FW: LU/46/26/DOC Condition 3

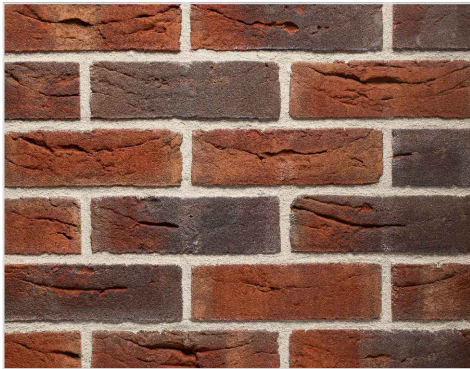
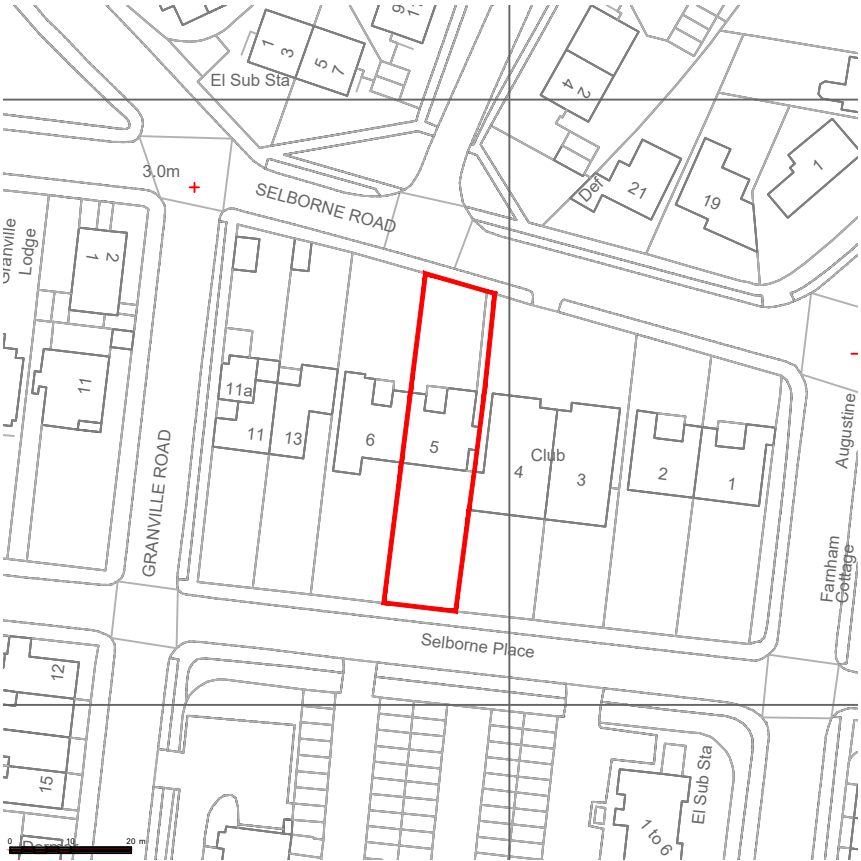
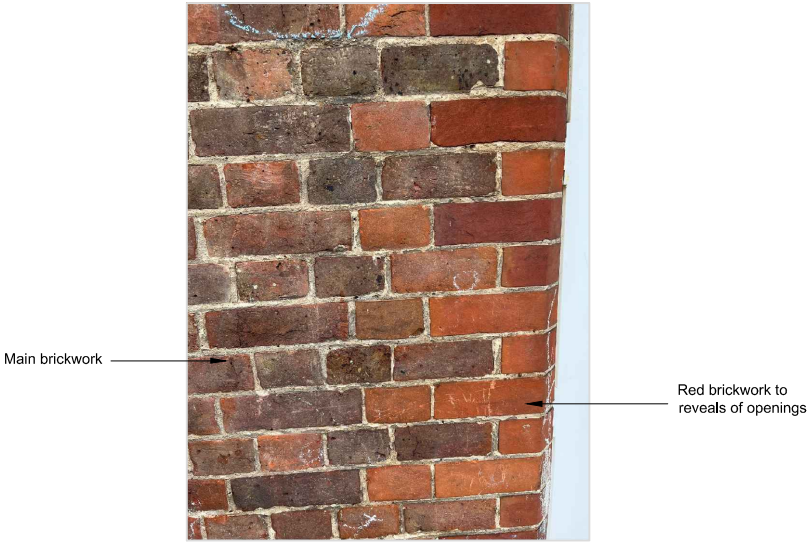
We've had a response from the Conservation Officer, he has stated the following: *'However, the mortar specification will be important to ensure that the new brickwork matches the existing. It should be appropriate in terms of its colour and its joint profile/thickness. If the mortar were to differ significantly in colour or if the joints were excessively thick, the result would be visually harmful. A mortar which matches the existing would be acceptable. Please could full details of the proposed mortar mix, colour and joint profile be provided.'*

I would be grateful if you could confirm the mix as you've suggested and confirm the arrangement/thickness of the joints.

I've had a brief discussion with my Conservation Officer regarding your submission. He is generally satisfied with its contents; however, he has requested confirmation that the mortar used will not be of a standard specification and that it will be produced to match, as closely as possible, the existing mortar colour.

1. Mortar added to the 'proposed materials' as follows:
To be a lime mortar, which is to match the existing mortar colour, joint profile and thickness as closely as possible. Brick manufacturer to advise on which lime mortar mix is suitable to ensure it is compatible with the bricks.
2. Additional note added to drawings as follows:
A sample brick panel for approval is to be provided on site, once a builder is appointed. This will include a test mortar mix to match to match the existing mortar colour, joint profile and thickness as closely as possible.
Brick manufacturer to advise on which lime mortar mix is suitable to ensure it is compatible with the bricks.
